**Consultation Response from KC,  
Lead Local Flood Authority**

**2024/92727 Land adjacent to, Ashbourne Drive, Liversedge**

**Erection of residential development 67 dwellings with associated access, parking, public open space, landscaping and infrastructure**

**Date Responded: 31<sup>st</sup> December 2025**

Drawing Title	Cross Sections		
Site	Ashbourne Drive, Cleckheaton		
Scale	1:1000 @A2	Date	19/09/24
Drawn	VB/MC	Checked	-
Drawing No.	Z168.007	Rev.	-
Thorpe Arch Grange Walton Road Thorp Arch LS23 7BA 01937 543599 www.newetthomes.co.uk

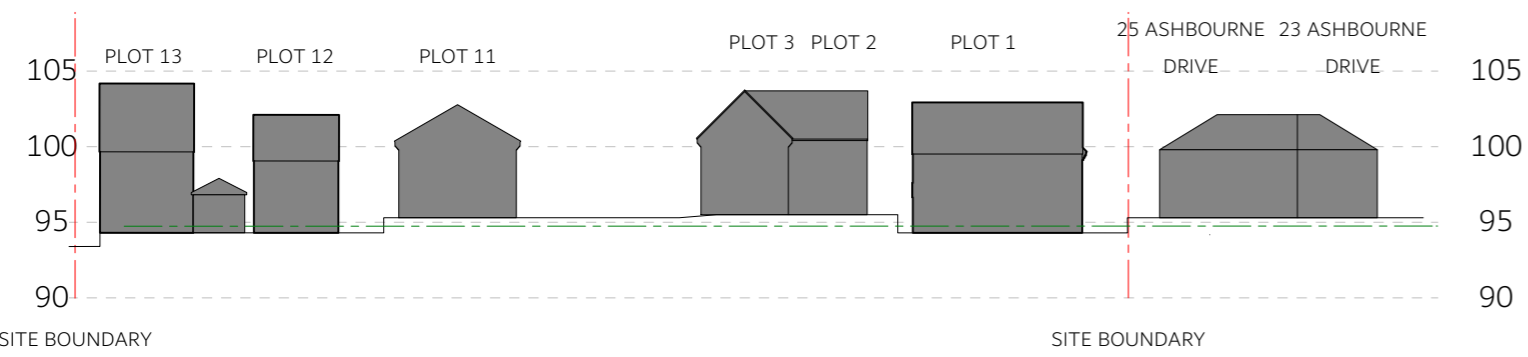
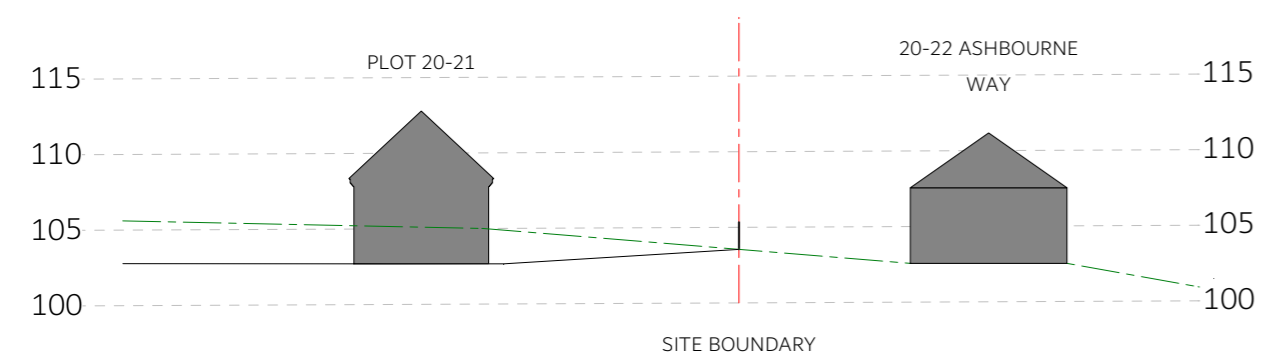
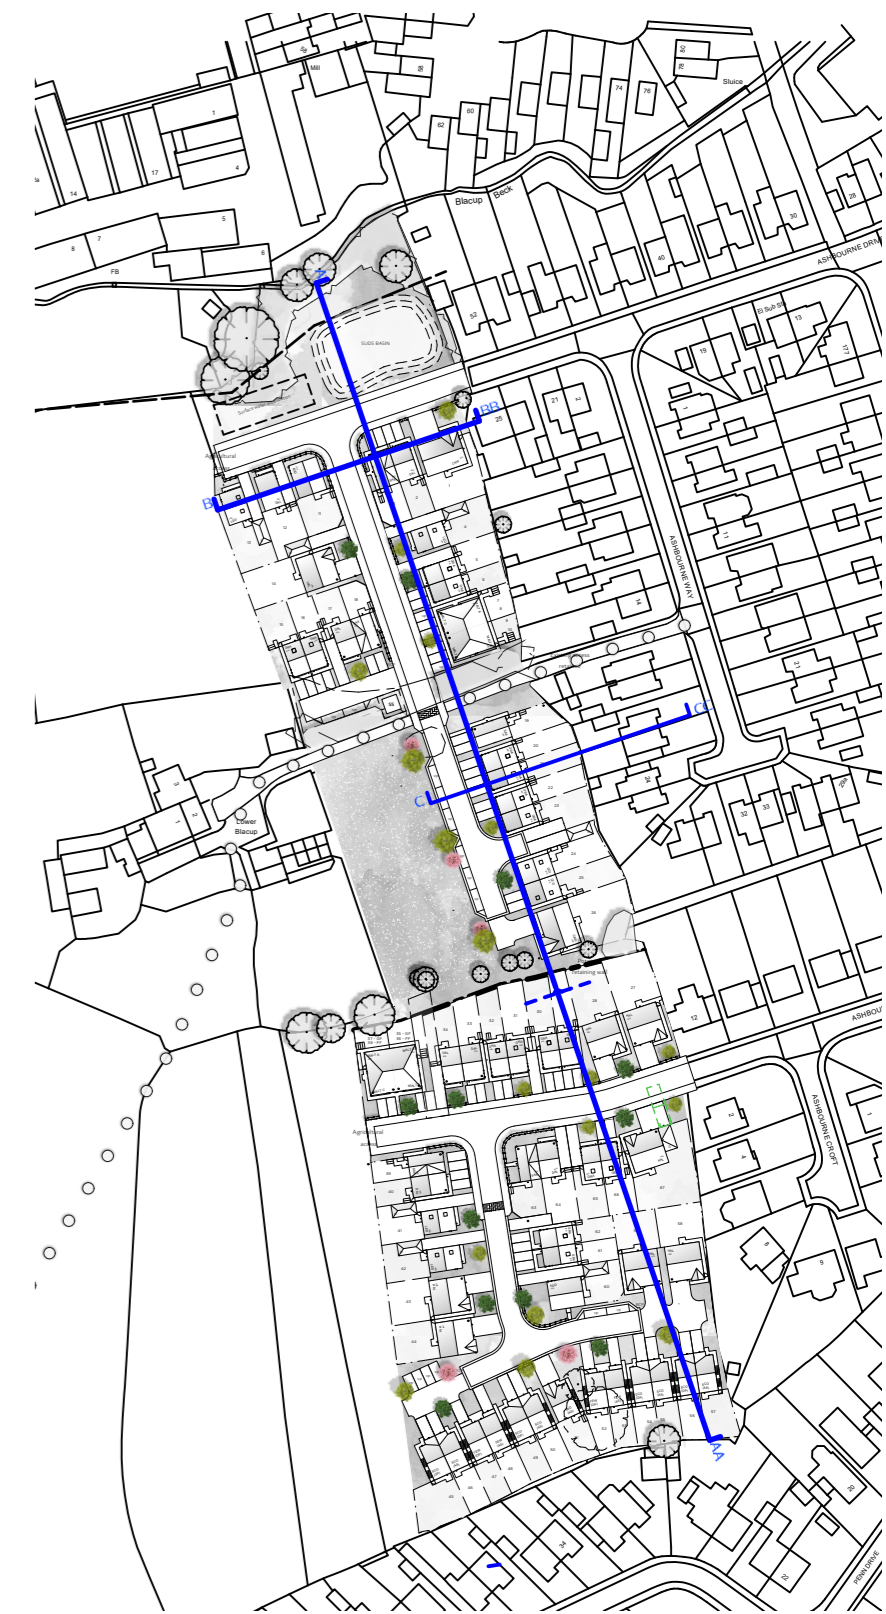
Kirklees Flood Management & Drainage acting as Lead Local Flood Authority previously supported this application. This is largely unchanged. However, we now have a concern over level within the site and at its boundary in the context of safe flood routing.

For the southern part of the site, blockage scenarios and exceedance events must direct flows into the public open space with a deliberate low spot in this area. Levels suggest this may is no longer the case and we now **OBJECT to this application subject to FURTHER INFORMATION** to be supplied.

Further information, such as an indicative engineering layout to demonstrate feasibility, showing labelled contours on roads and pavement. The top half of the site must have the majority of flows in a blockage scenario and exceedance event, flowing to the west, not into Ashbourne Way, i.e. the existing farm. Flows should move north toward Blacup Beck.

It may be prudent to provide a permitter swale to be maintained by a management company to intercept overland flows from the south and move water potentially coming in from outside the development areas northward along the boundary (or if agreed, in 3<sup>rd</sup> party land), with a designated route to Blacup Beck. Flows from the southern part of the site could utilise this swale.
